Application No: P/53/22/DOC
Site Address: Land at Spinnaker View Pagham
Description of works: Approval of details reserved by condition imposed under P/165/21/PL relating to condition 3-Arboricultural Method Statement and tree protection plan.

Thank you for your internet representation made on 22nd April 2022 which has been recorded as an objection with the comments as follows:

**Spinnaker View**  
**Appendix 2 - new site layout plan**

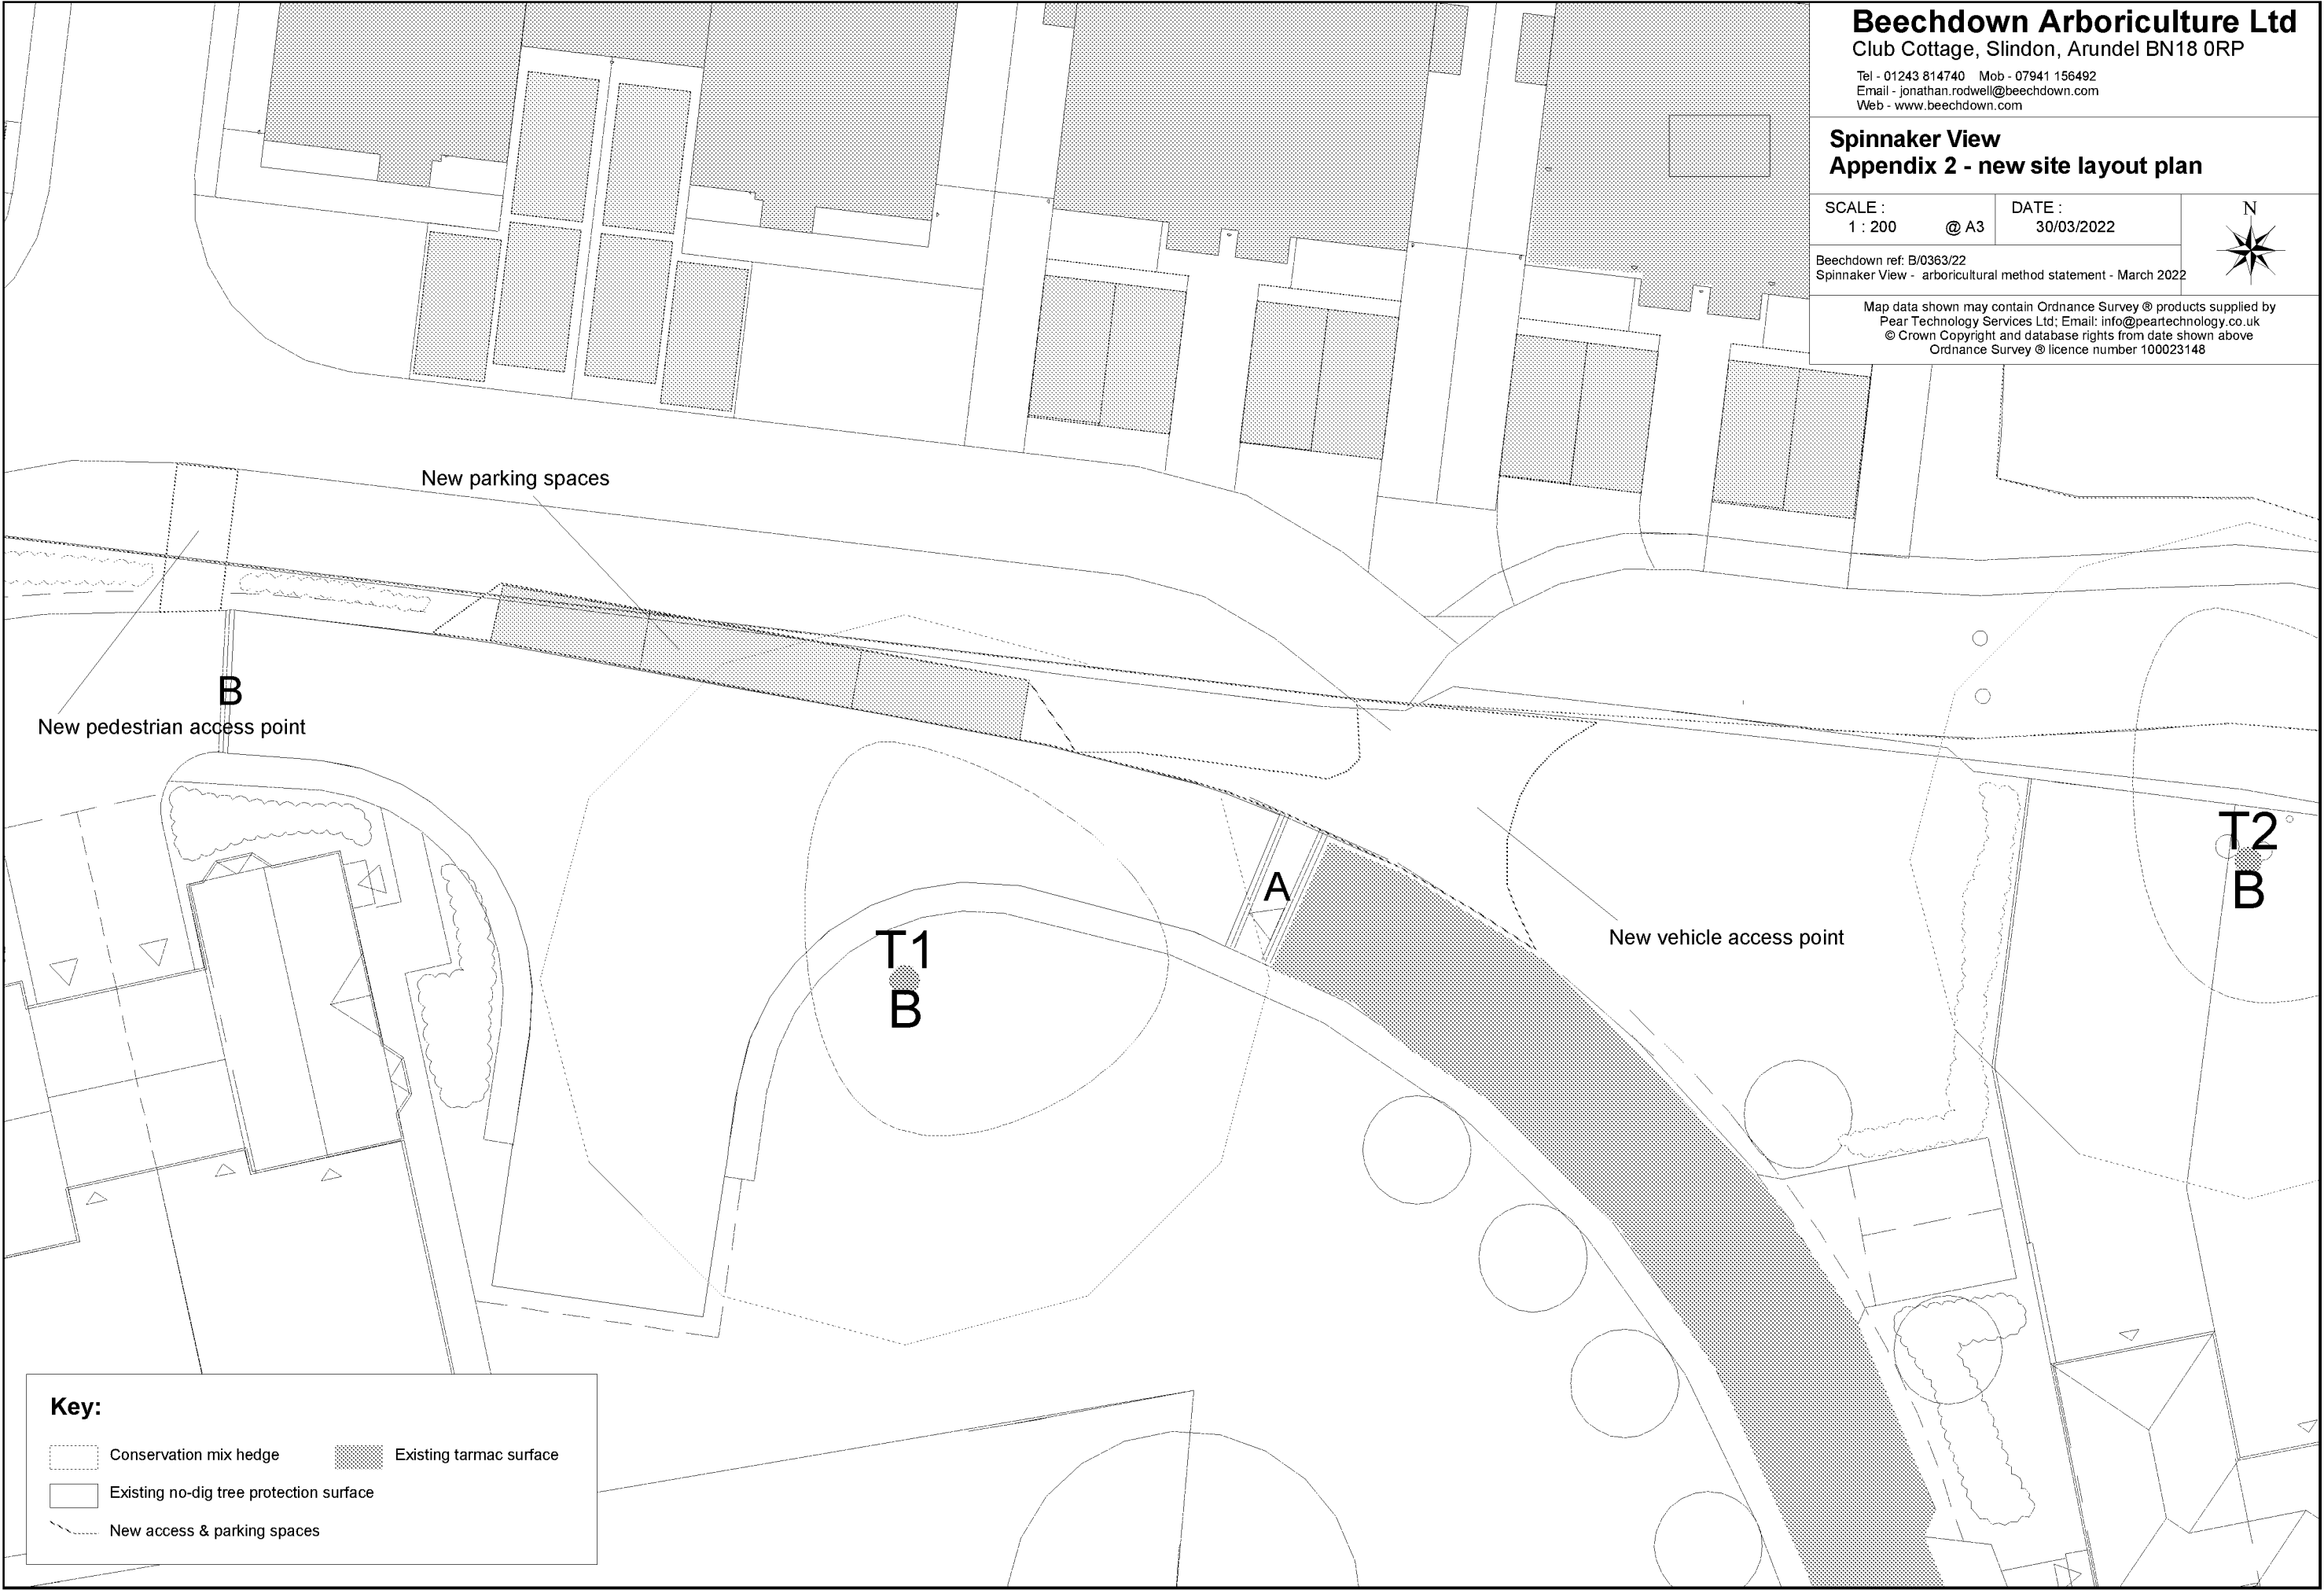
Secondly the plans show moved parking spaces which are between the boundary lines. This plan is either vastly inaccurate to make the plans appear suitable for the no dig zone or this developer is giving spinnaker view additional land? It is unclear which one it is. I'm not entirely sure how a dustcart will be able to swing round with cars parked in the proposed parking spaces.

Thirdly why does this developer persist in moving our parking spaces and destroying our wildlife zone to make room for their new road. Wouldn't it make more sense to leave the spaces where they are and make a cut through the fence so no alterations to spinnaker view are made? There is still no permission for access but this would make more sense.
